Site 9. Brooke,

Brooke Parish Council

Written response to Hearings

Consultation Comments on Site 9 (Brooke) Heritage Assessment

Figure 7.5.3
Site 9 Zone of Theoretical Visibility
Sheet 1 - With View Locations (DTM and DSM)

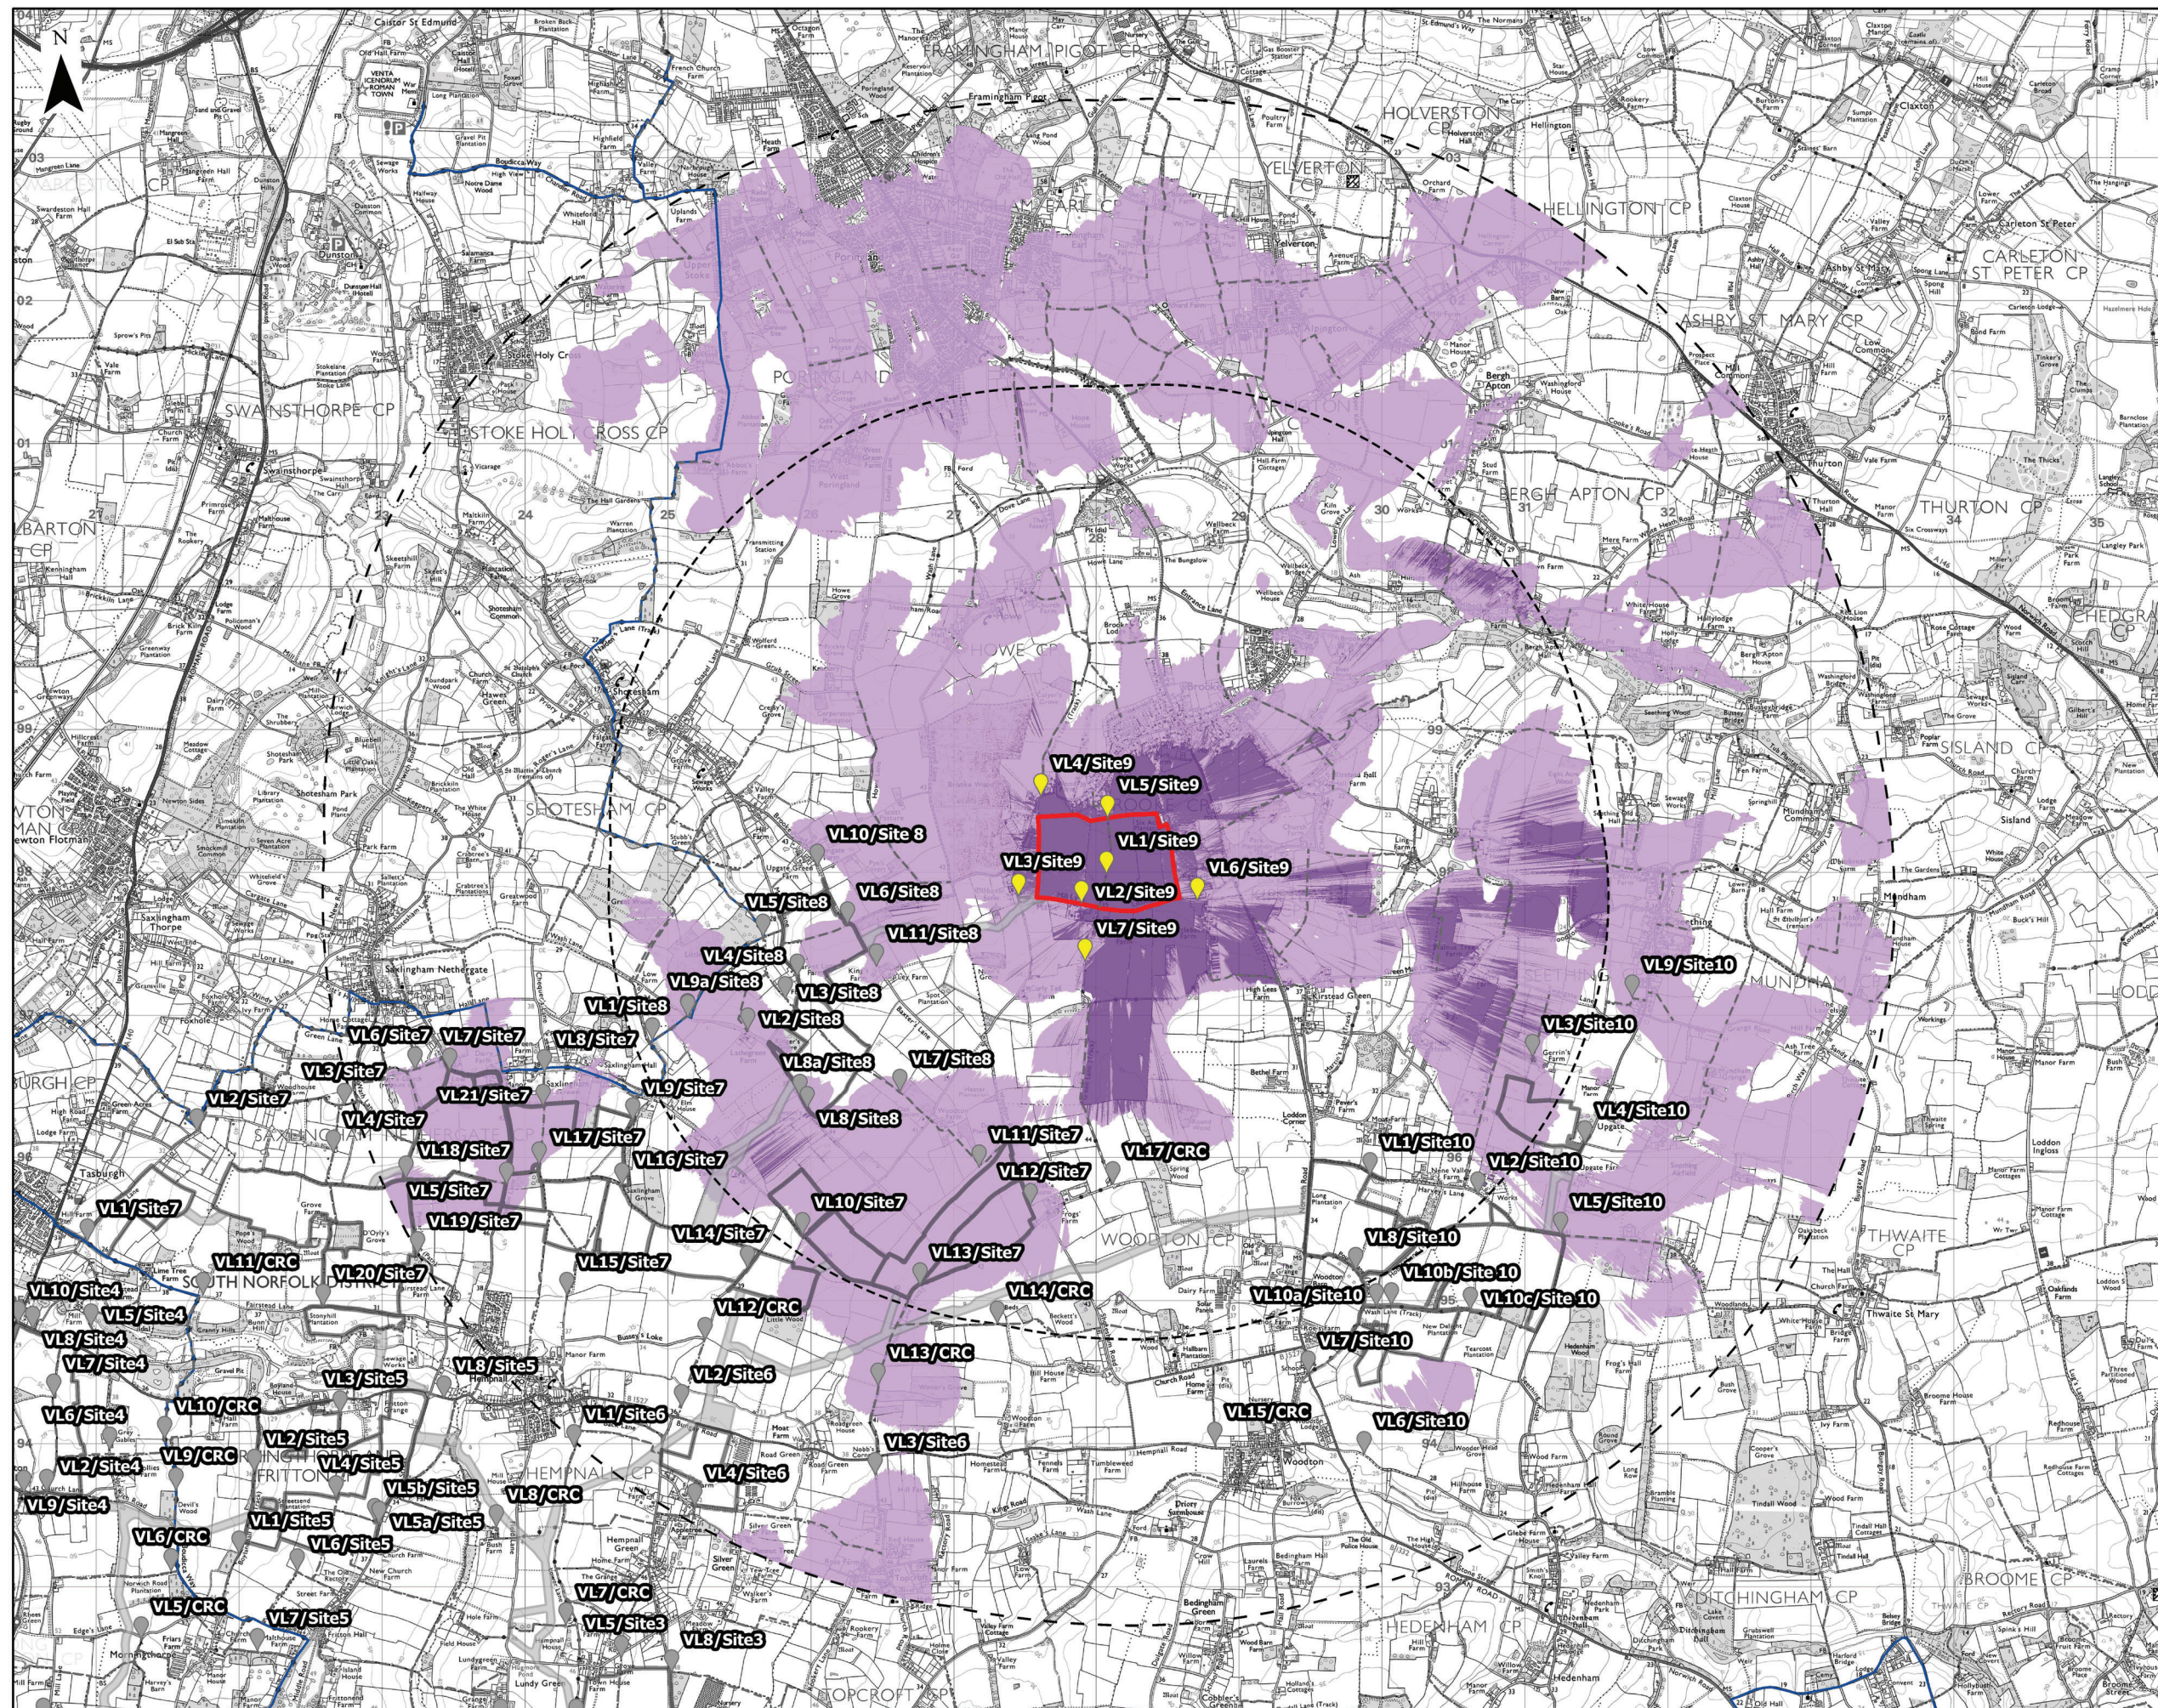
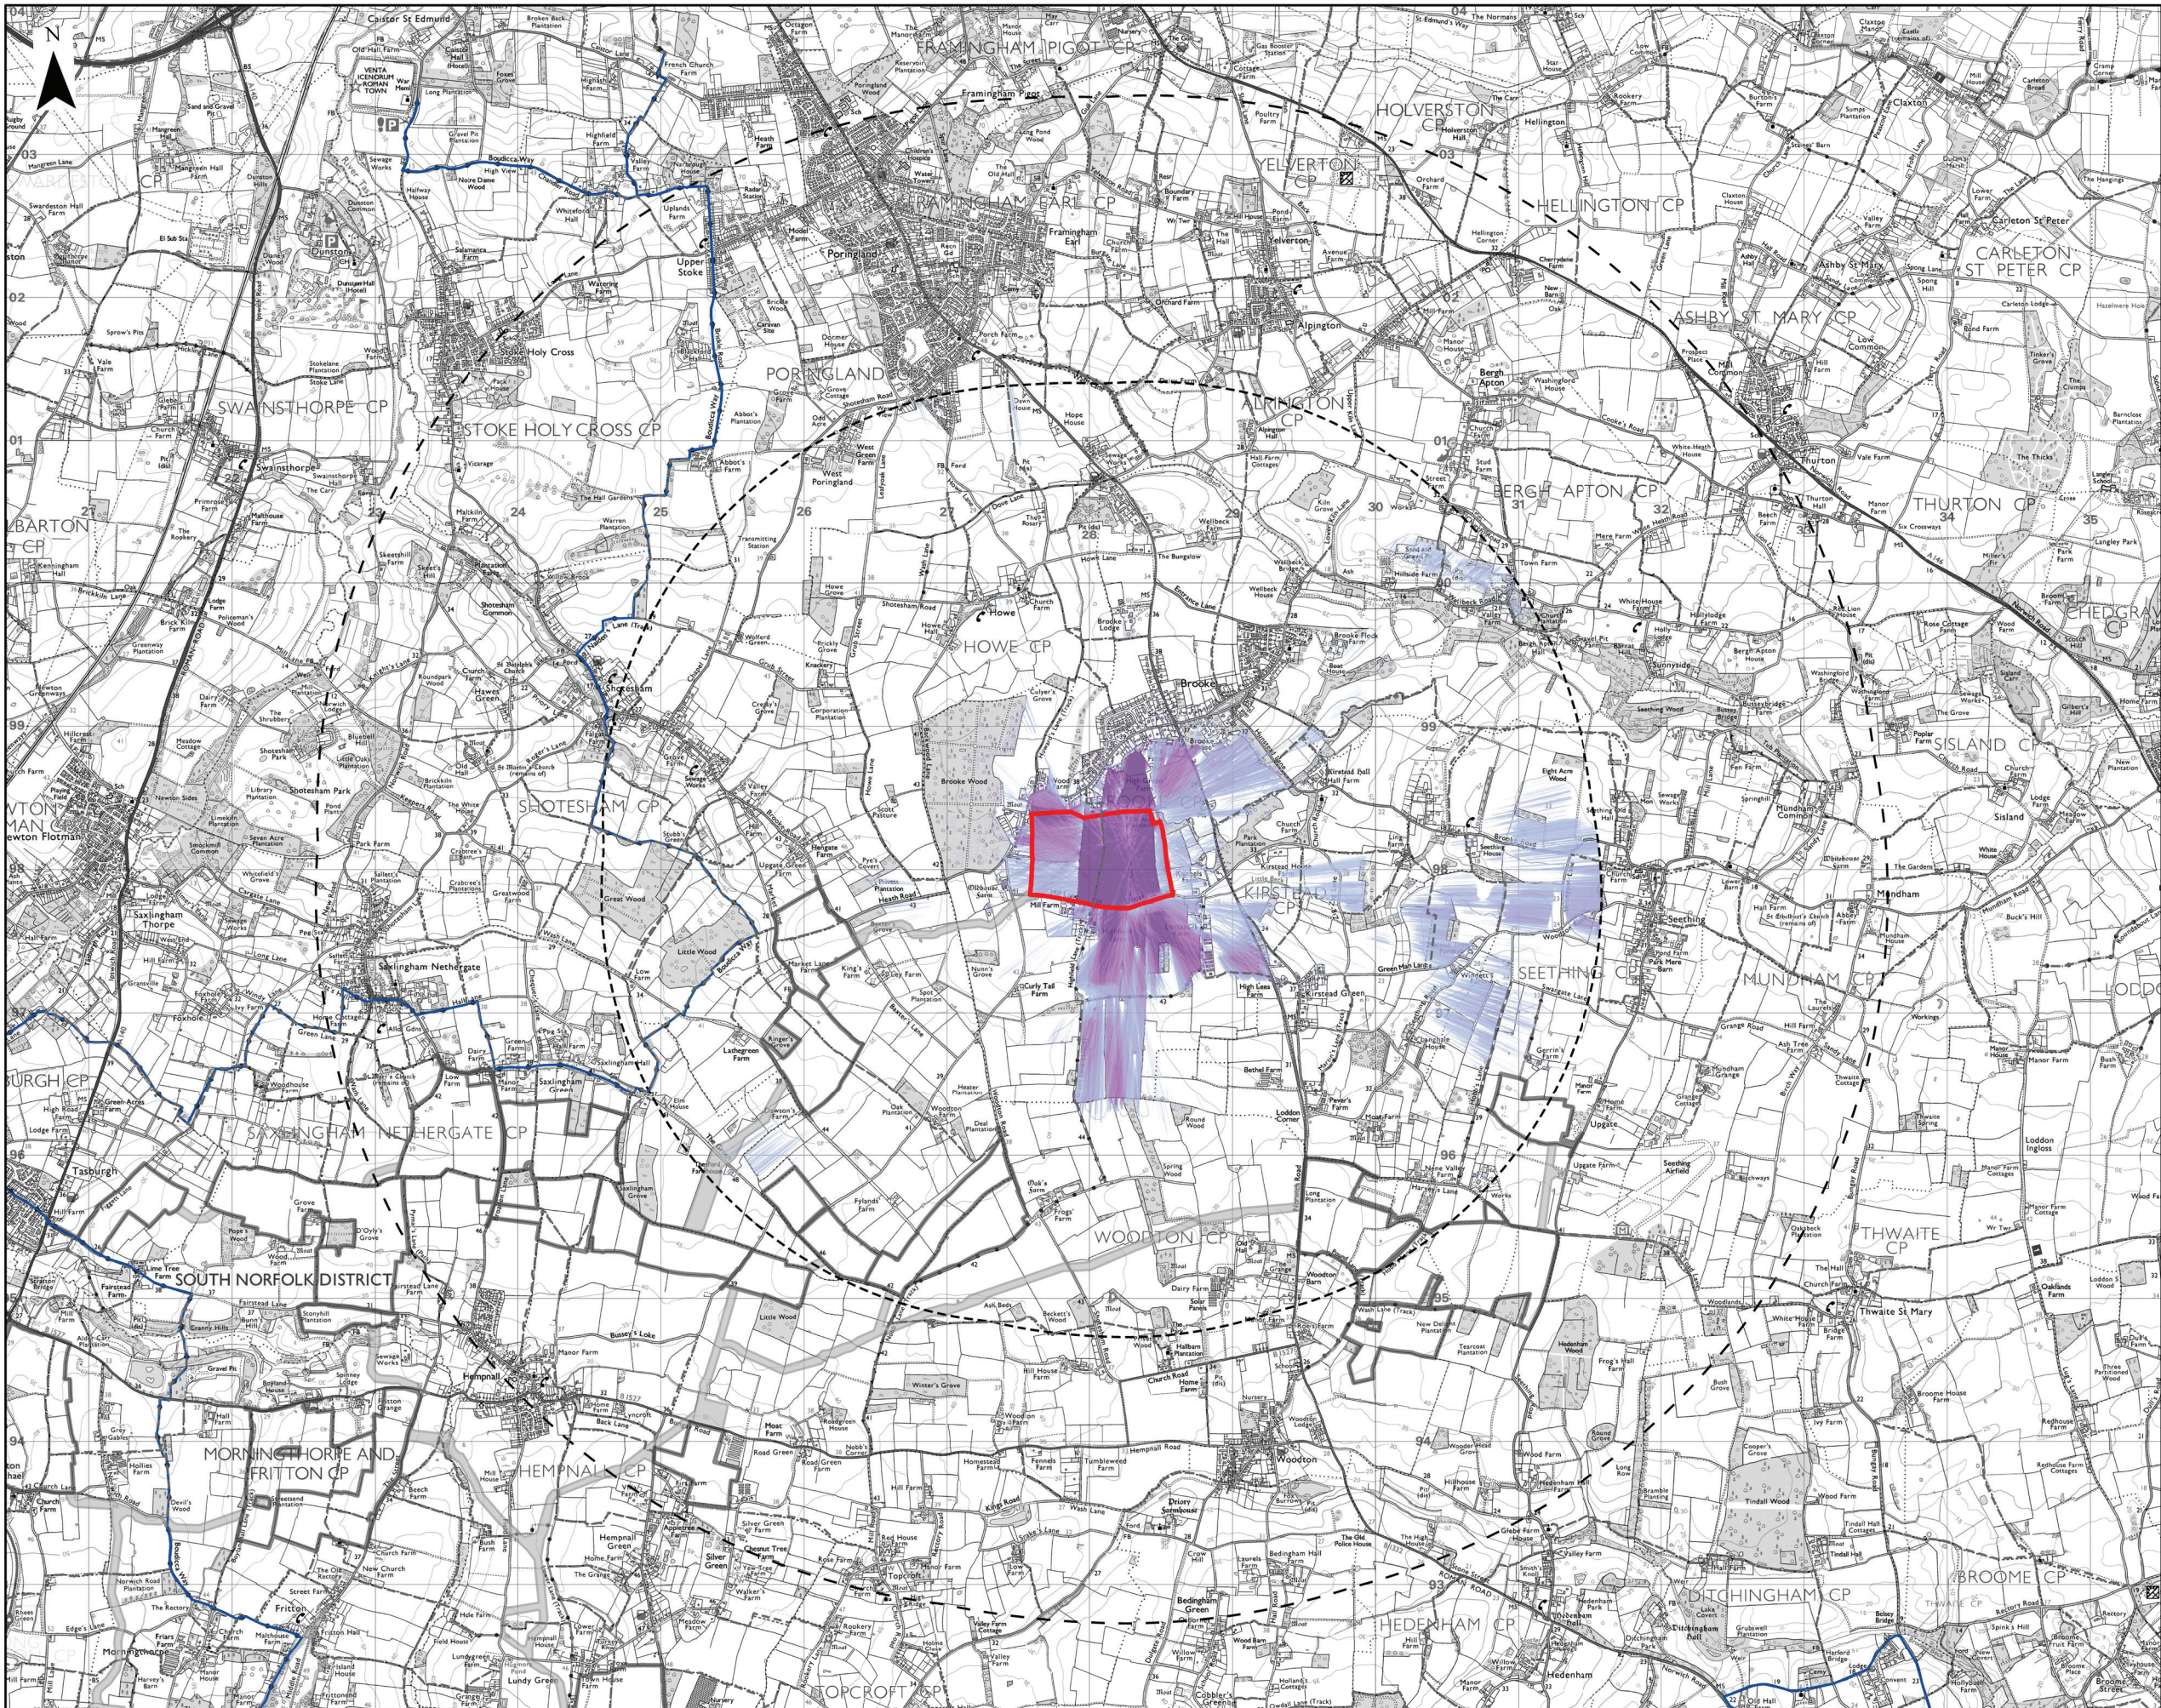
Comment 3: Insufficient Assessment of Winter Visibility

The assessment acknowledges the existence of occasional and filtered views between Site 9 and nearby heritage assets, particularly during periods when vegetation cover is reduced. However, no detailed assessment of winter or leaf-off visibility has been presented. The absence of seasonal visualisations, photomontages, or a worst-case assessment limits confidence in the conclusion that no harm would arise. Additional evidence should be provided demonstrating the appearance of the scheme from relevant heritage receptors during winter conditions.
